October 7, 2024

**Re: Santa Barbara Multigeneration Center**  
**1825 Edith Blvd. NE**  
**30-Day Temporary Certificate of Occupancy**  
**Transportation Development Final Inspection**  
Engineer's Stamp dated 05-26-23 (H15-D070)  
Certification dated 06-06-24

Based upon the information provided in your submittal received 10-02-24, Transportation Development has no objection to a 30-day Temporary Certificate of Occupancy based. This letter serves as a "green tag" from Transportation Development for a 30-day Temporary Certificate of Occupancy to be issued by the Building and Safety Division.

C-100

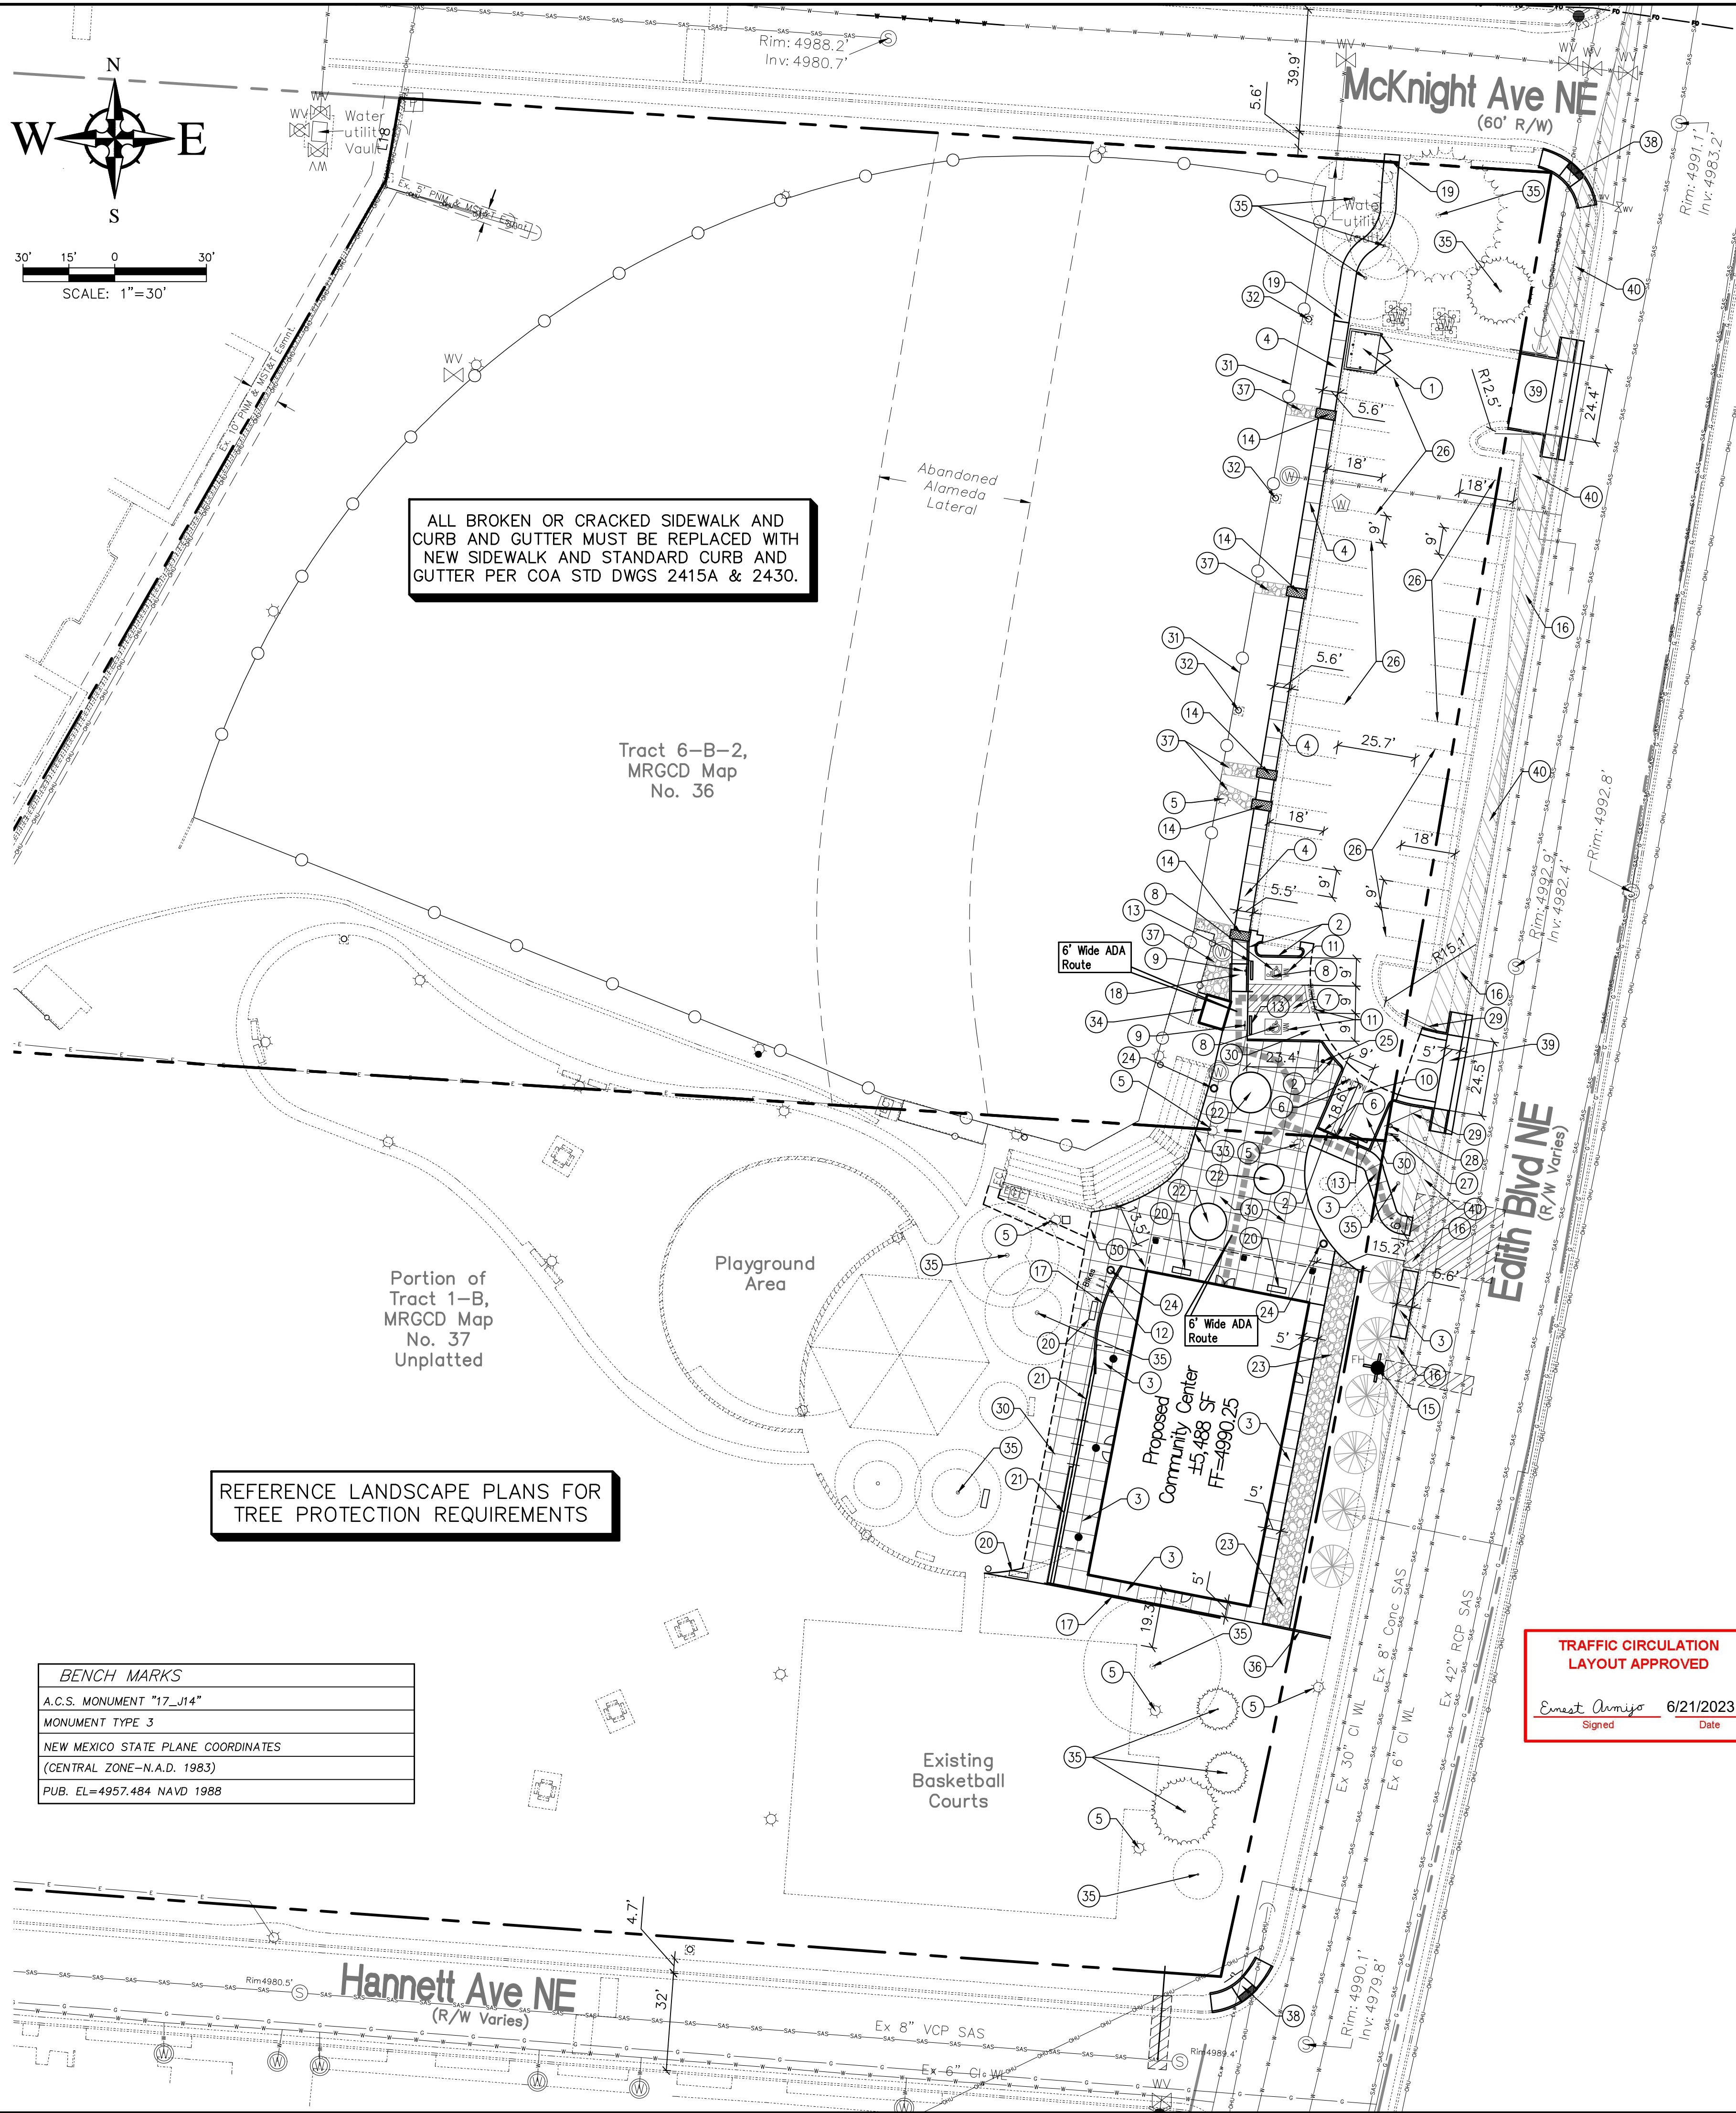
- Provide Motorcycle parking sign.
- Based on the site visit, the cross slope of the south site access off Edith is 3.8%, while ADA requirements specify the slope should not exceed 2% in all direction. This site access should be upgrade to meet the current ADA standard.
